Aquind Interconnector - Response from Environmental Protection

Documents reviewed:

Matters assessed:

Figure 24.4  
Section 1 - predicted broadband noise levels (pre additional mitigation) from operational converter station (Option B (ii)) and equipment included in noise model.  
Sheet 1 of 1

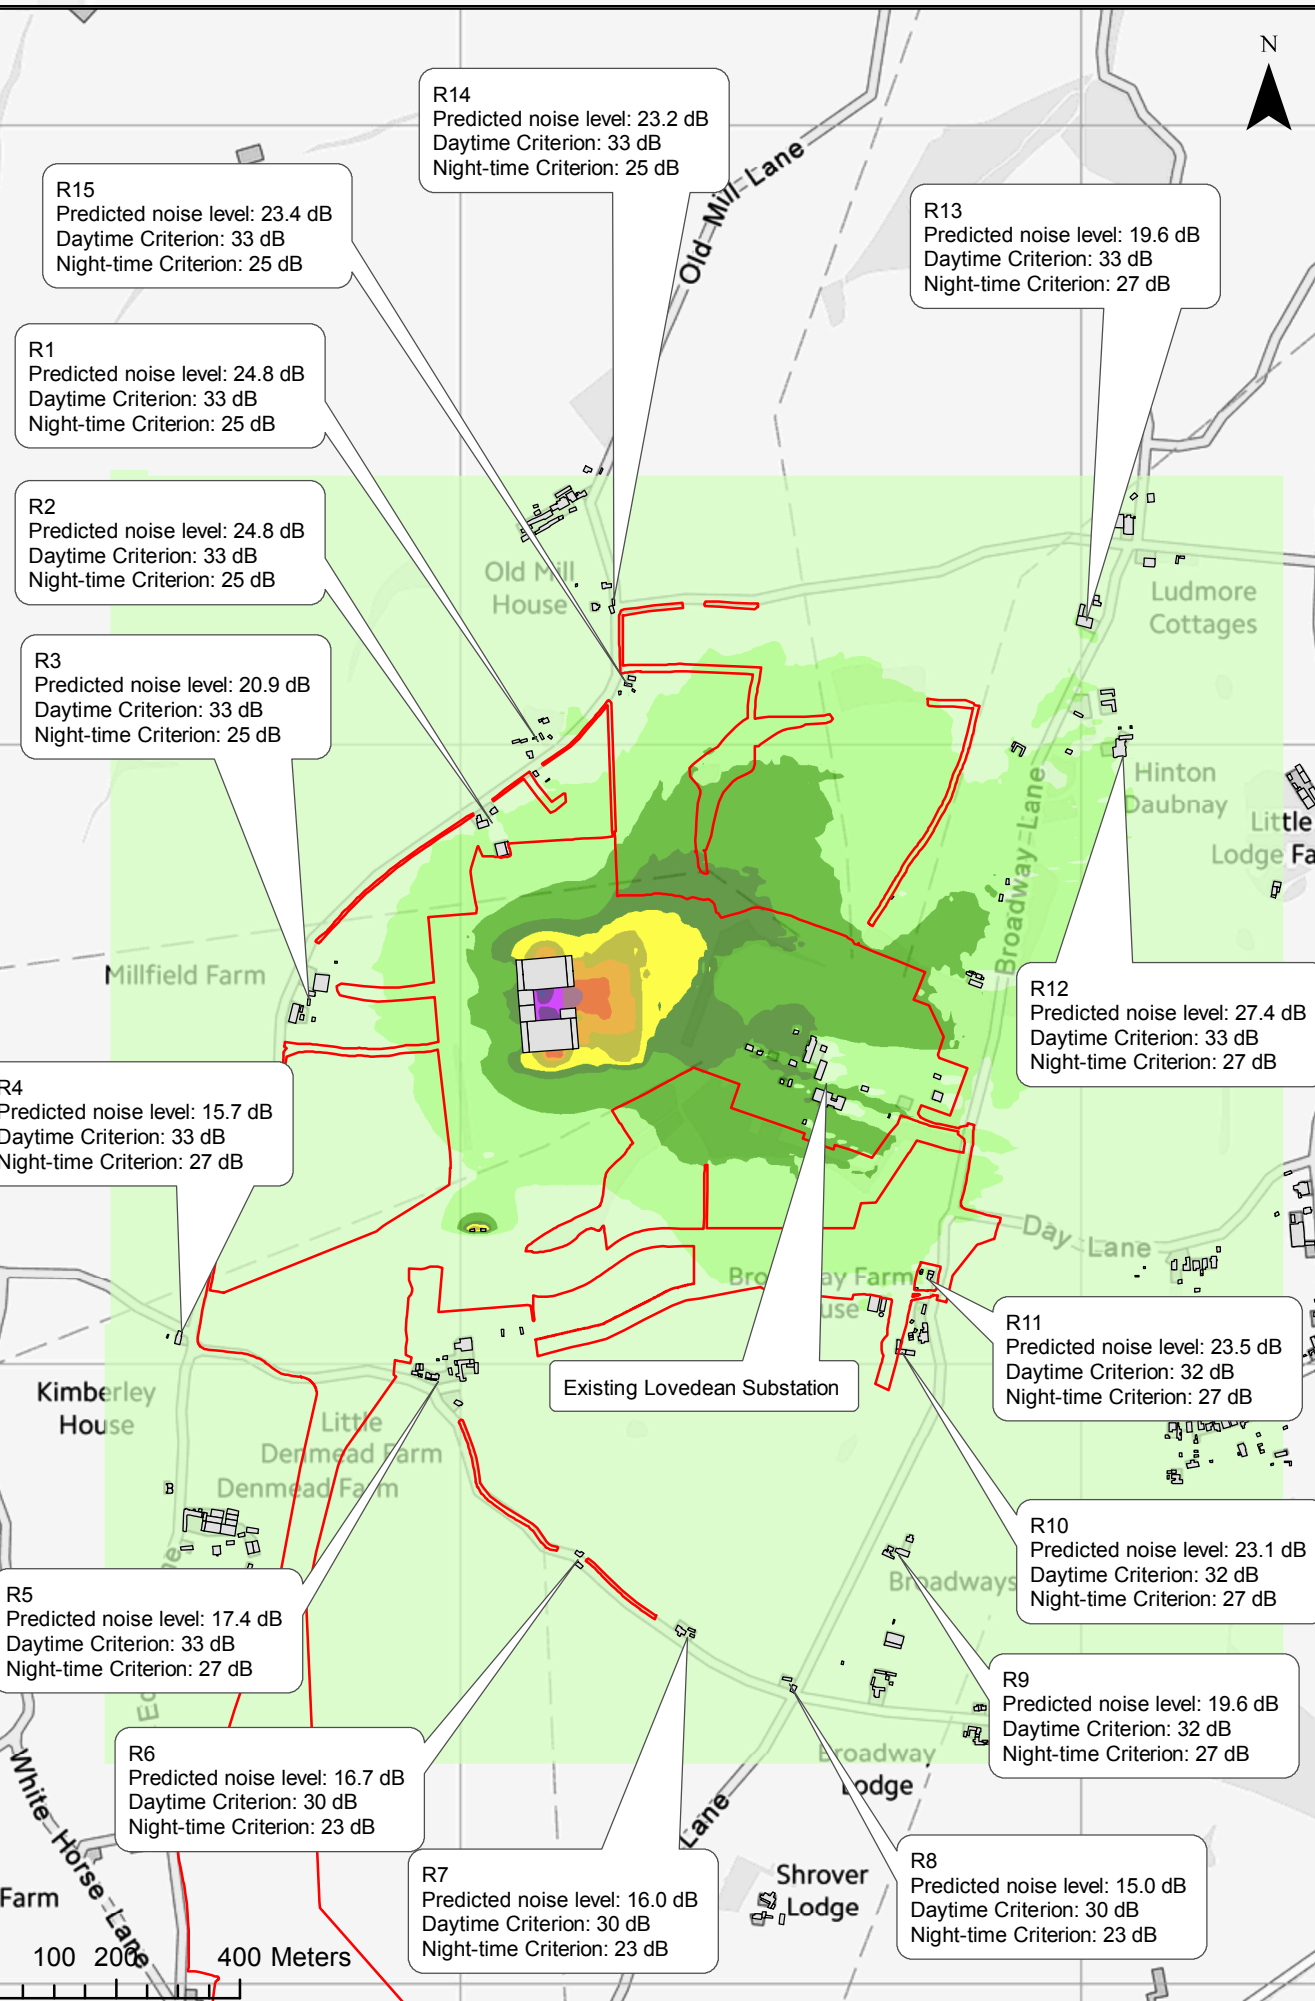
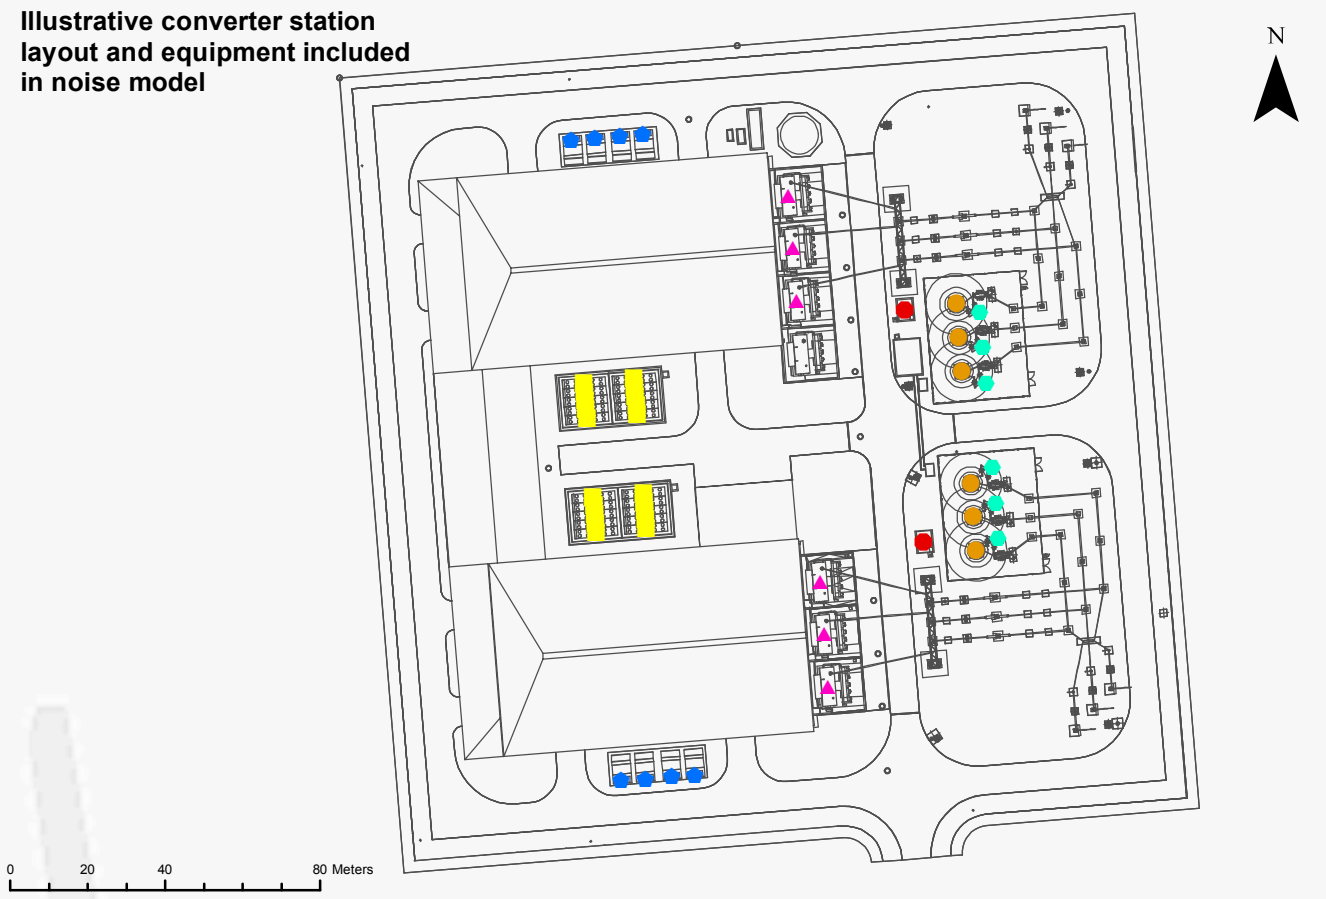
I have serious concerns regarding the wording of this section as I do not consider this gives sufficient confidence in the level of noise mitigation that will be achieved for the Converter station will be as detailed in in Document 6.1.24 – Chapter 24 Noise and Vibration - Volume 1 (plus associated Volume 2 appendices).

Although it is appreciated that the final design and specific equipment has not been finalised there are significant assumptions made within the noise assessment to derive the conclusion that the impacts from the converter station are negligible. Specially in addition to the assumed embedded mitigation measures (section 24.6) additional mitigation measures are identified in section 24.8(proposed mitigation and enhancement) with regards to one exposure location.

It is therefore considered that this section needs to be reworded to ensure these specific requirements form part of the measures being proposed. This section needs to cross reference the measures identified within Documents 6.1.24 (sections 24.6 and 24.8) and this might also need to be added to Schedule 14 (Certified Documents).
